**Cherwell District Council: Begbroke Science Park, Begbroke Hill,
Begbroke, Kidlington, OX5 1PF – Non-Material Amendment to
Condition 2 of Reserved Matters Permission ref. 21/03150/REM**

On behalf of our client, Begbroke Oxford Limited (BOL), please find enclosed an application for a Non-Material Amendment (NMA) to Condition 2 of Reserved Matters Approval ref. 21/03150/REM (dated 27 January 2022) relating to Begbroke Science Park for:

As BOL has progressed with the detailed design of the Reserved Matters Approval it has become apparent that there is a need for a minor change to the design to ensure one of the proposed gas stores adjacent to the Commercial Building avoid an existing Manhole, moving it 1800mm north.

**PLANNING - PROPOSED GROUND FLOOR
PLAN - COMMERCIAL BUILDING**

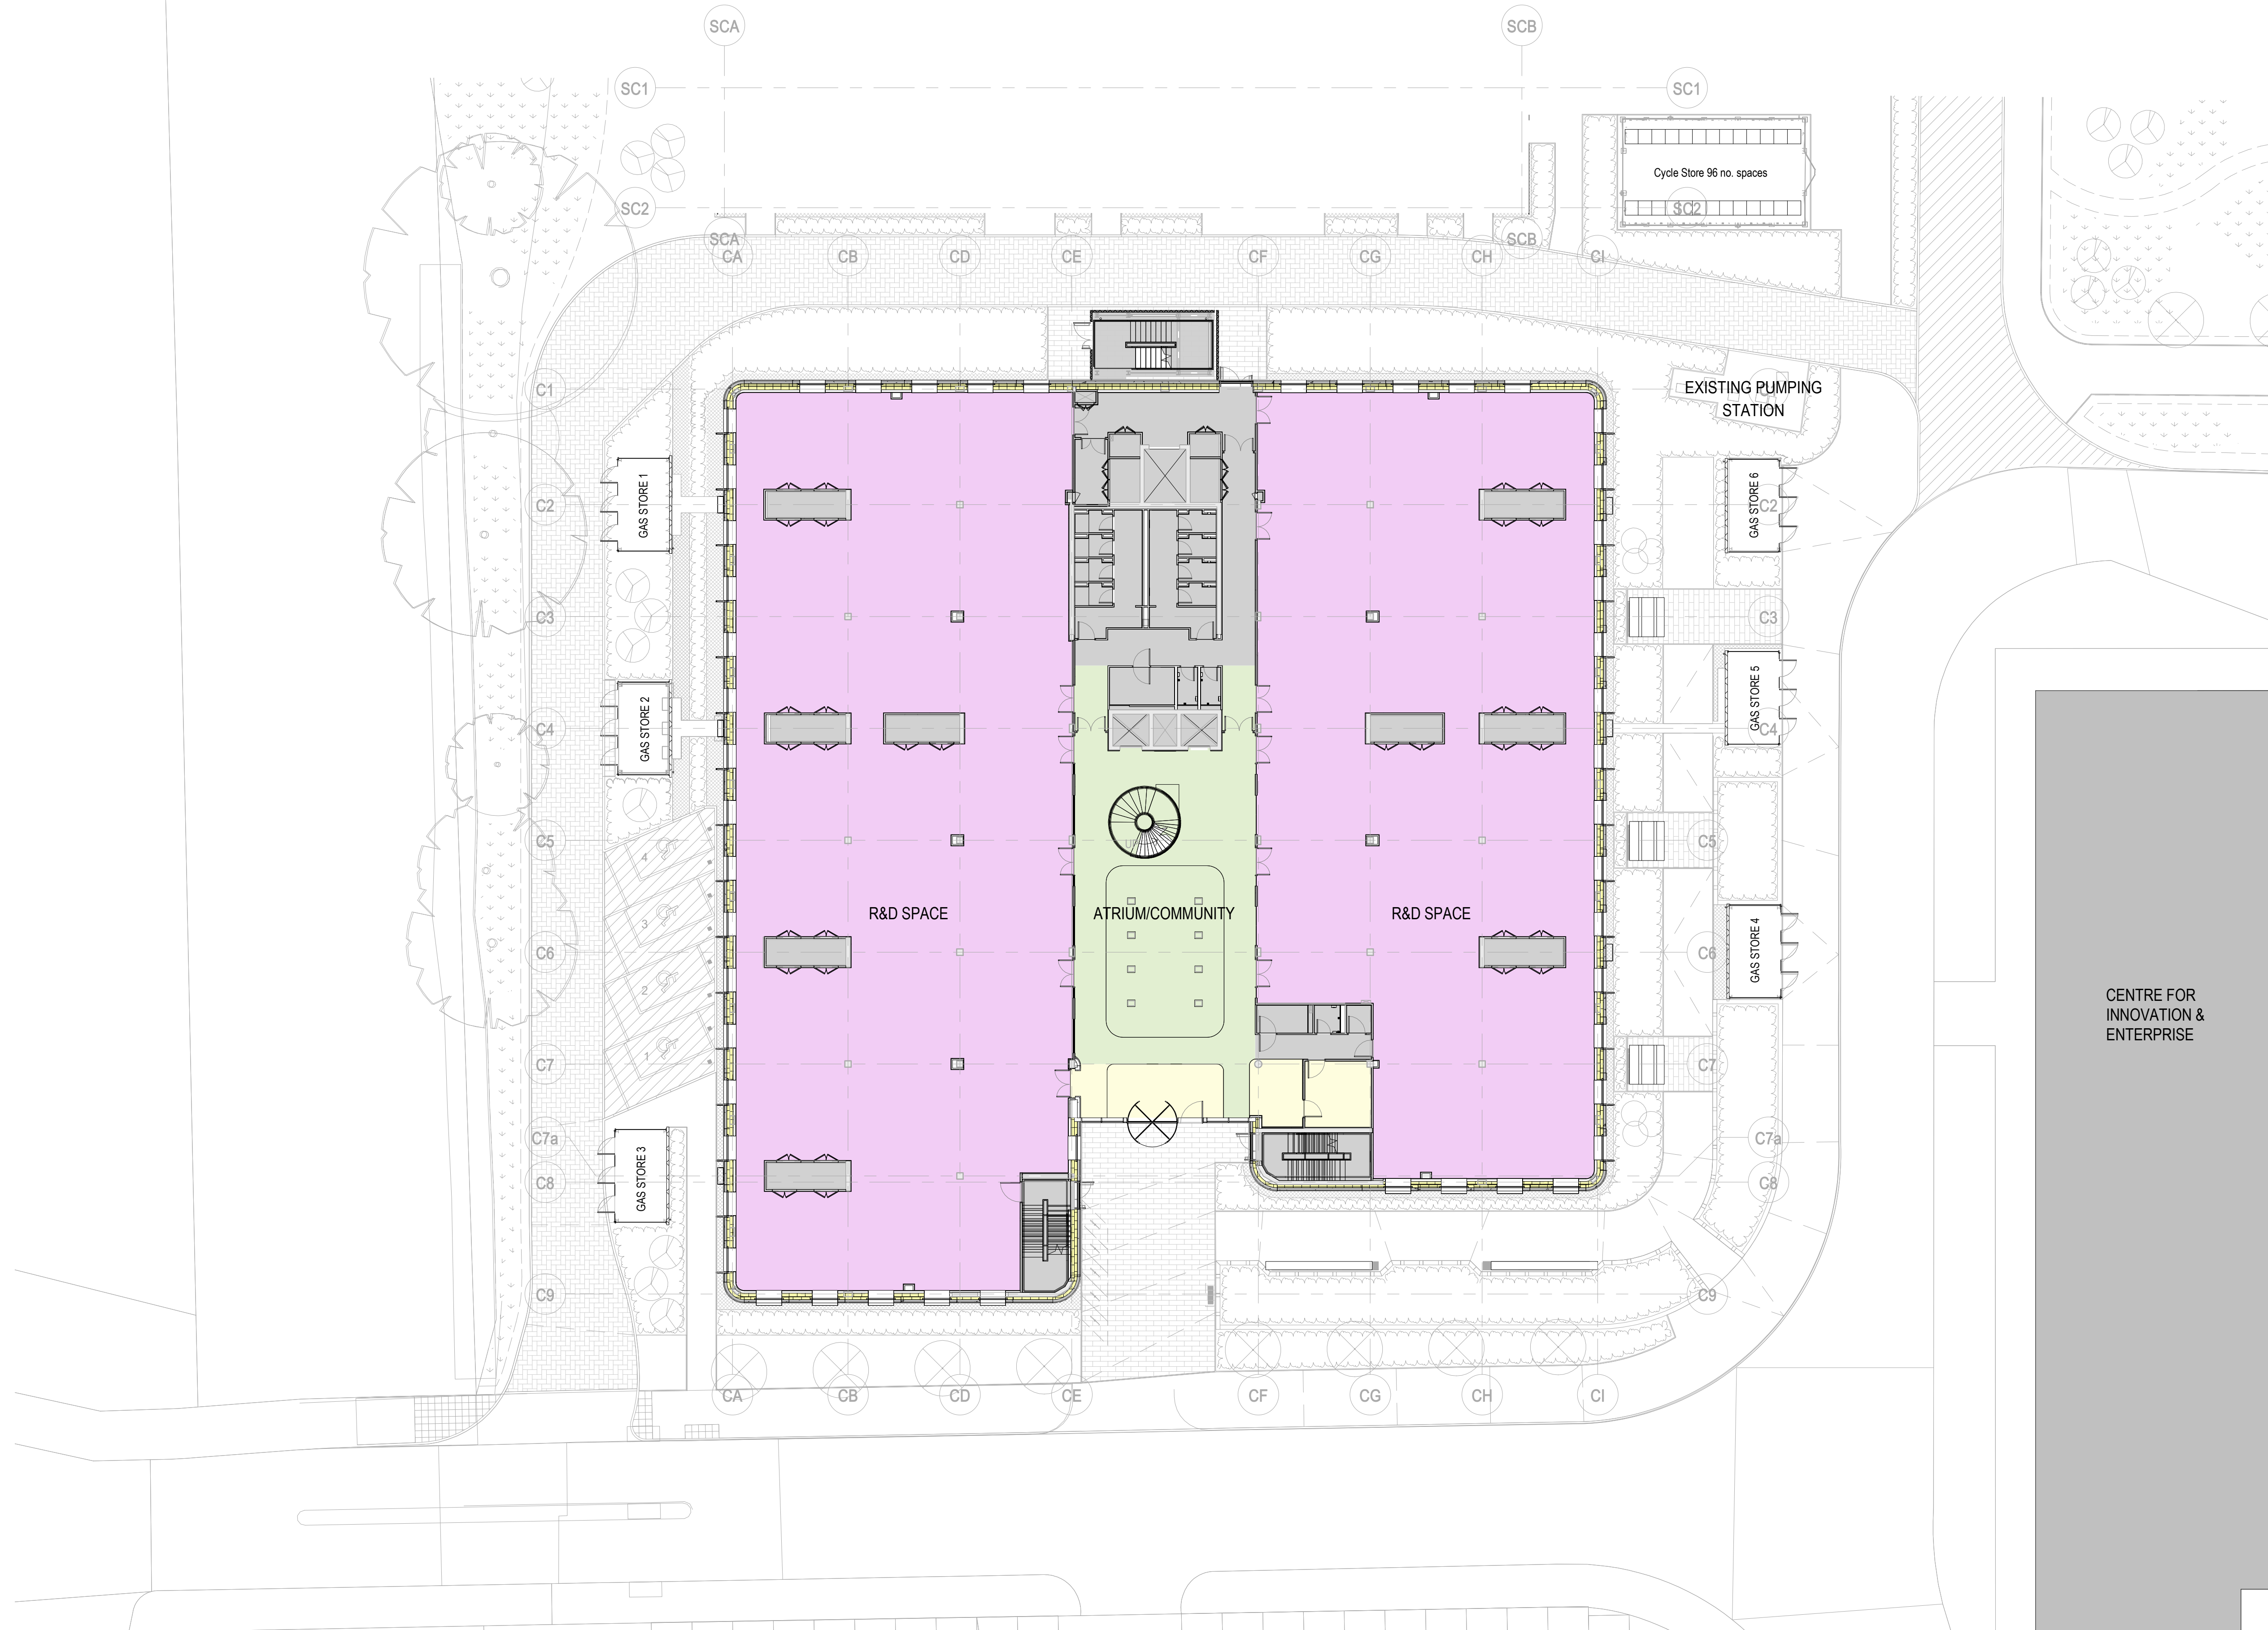
The proposed minor change to the location of 1no. gas store is required on health and safety grounds to ensure full access to the existing manhole. This will not result in a material change to the form or layout of the overall development. On this basis, it is not considered that the proposed change would modify the development to such an extent as to constitute a material amendment to the scheme.
